Our Ref: AL/72/14/HH
Your Ref:

Application for Planning Permission for Works or Extension to a Dwelling

Development Roof extension with new staircase over single storey accommodation & extension on west elevation.

Location Caigers Cottage Westergate Street Aldingbourne

EXISTING PLANS

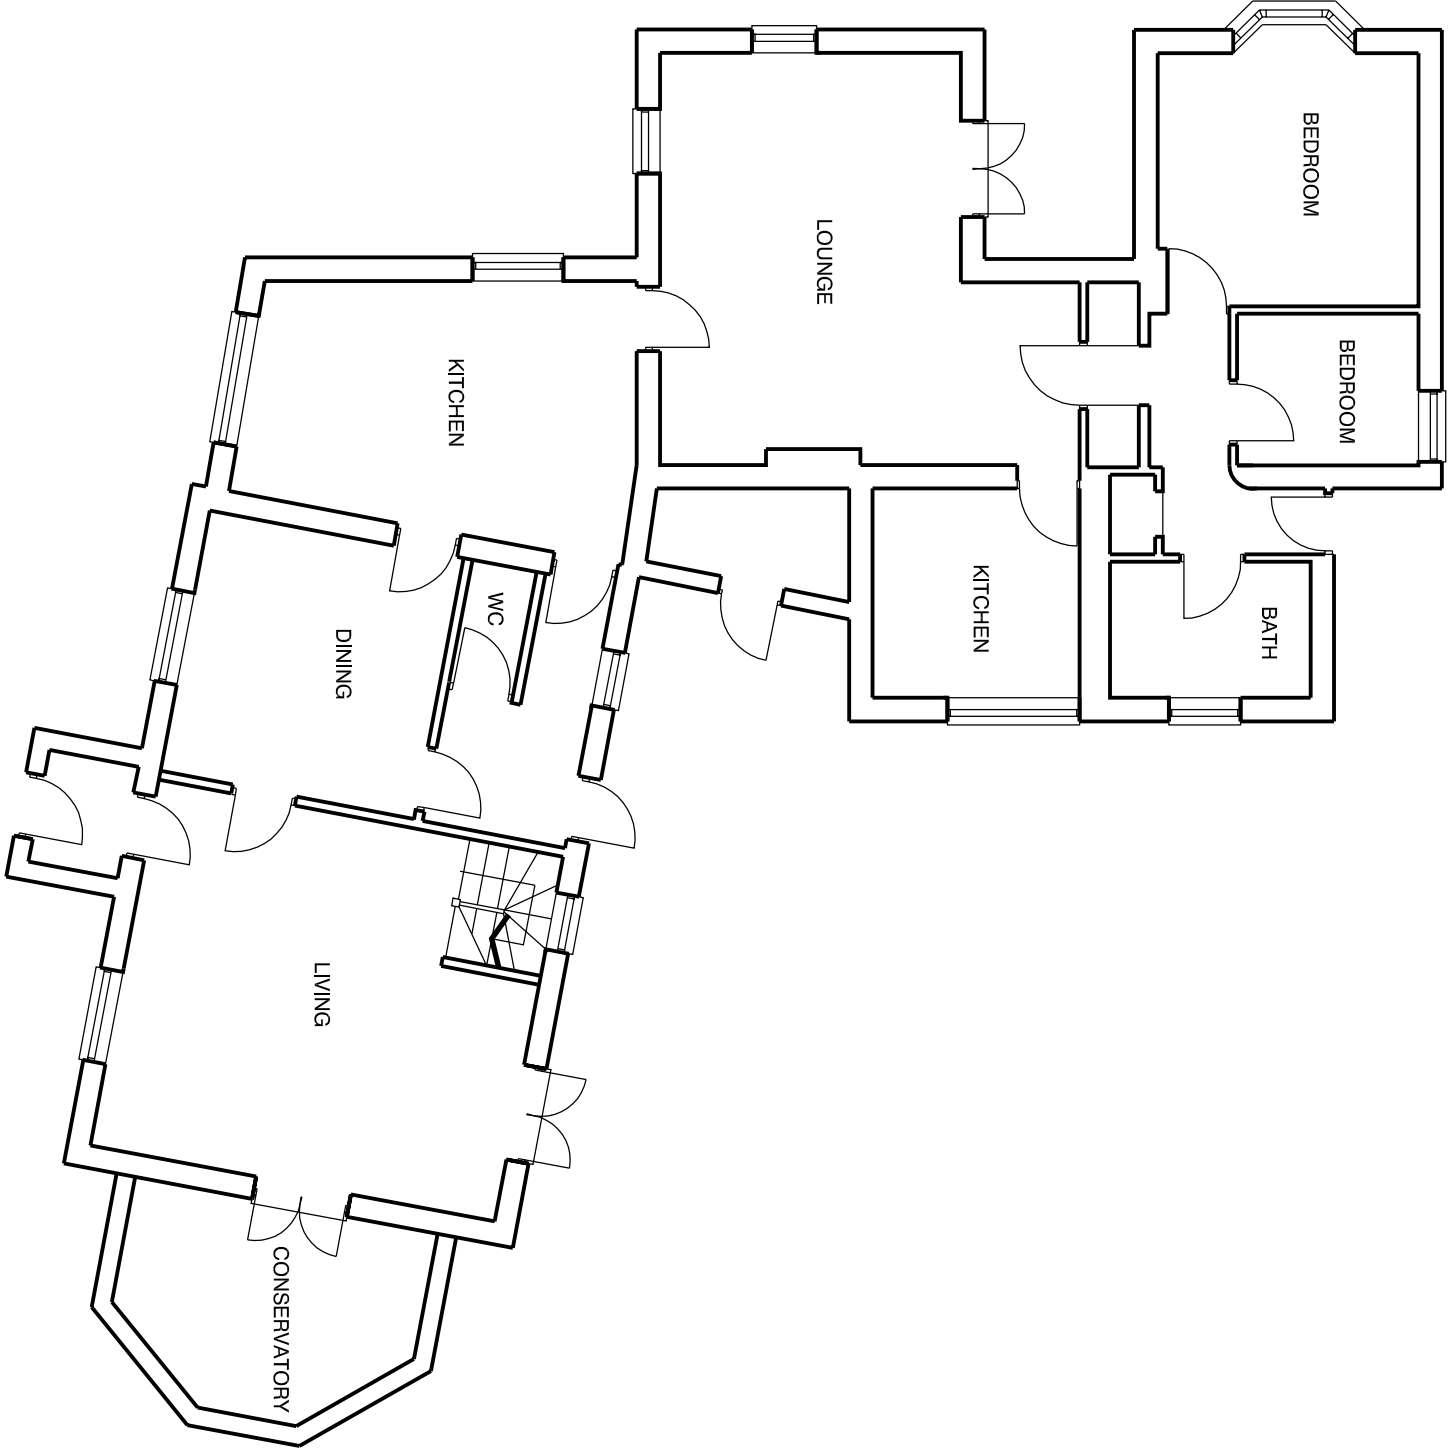
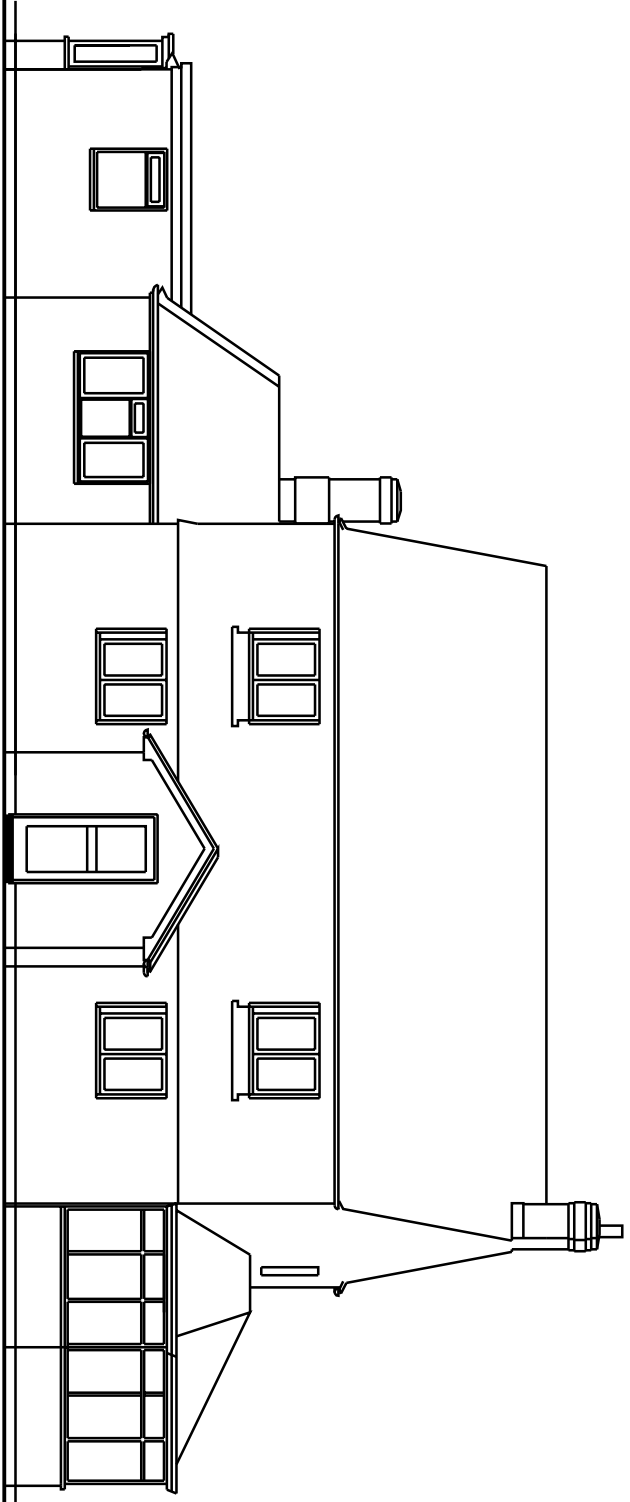
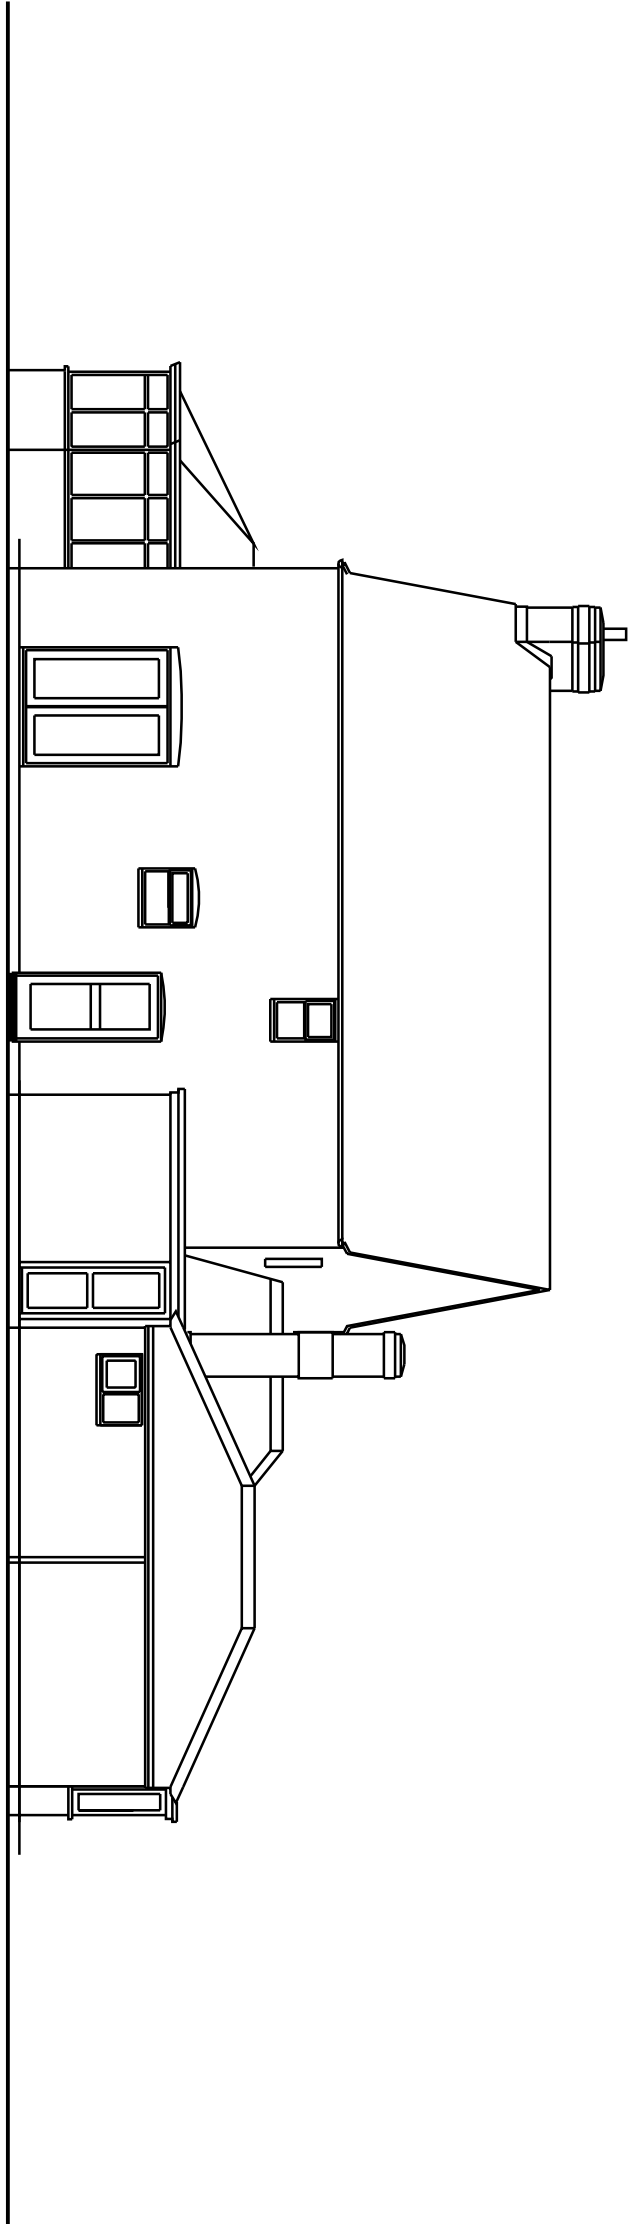
The existing and proposed floor plans and elevations at ground floor level at the north and south do not accord. Please amend accordingly.
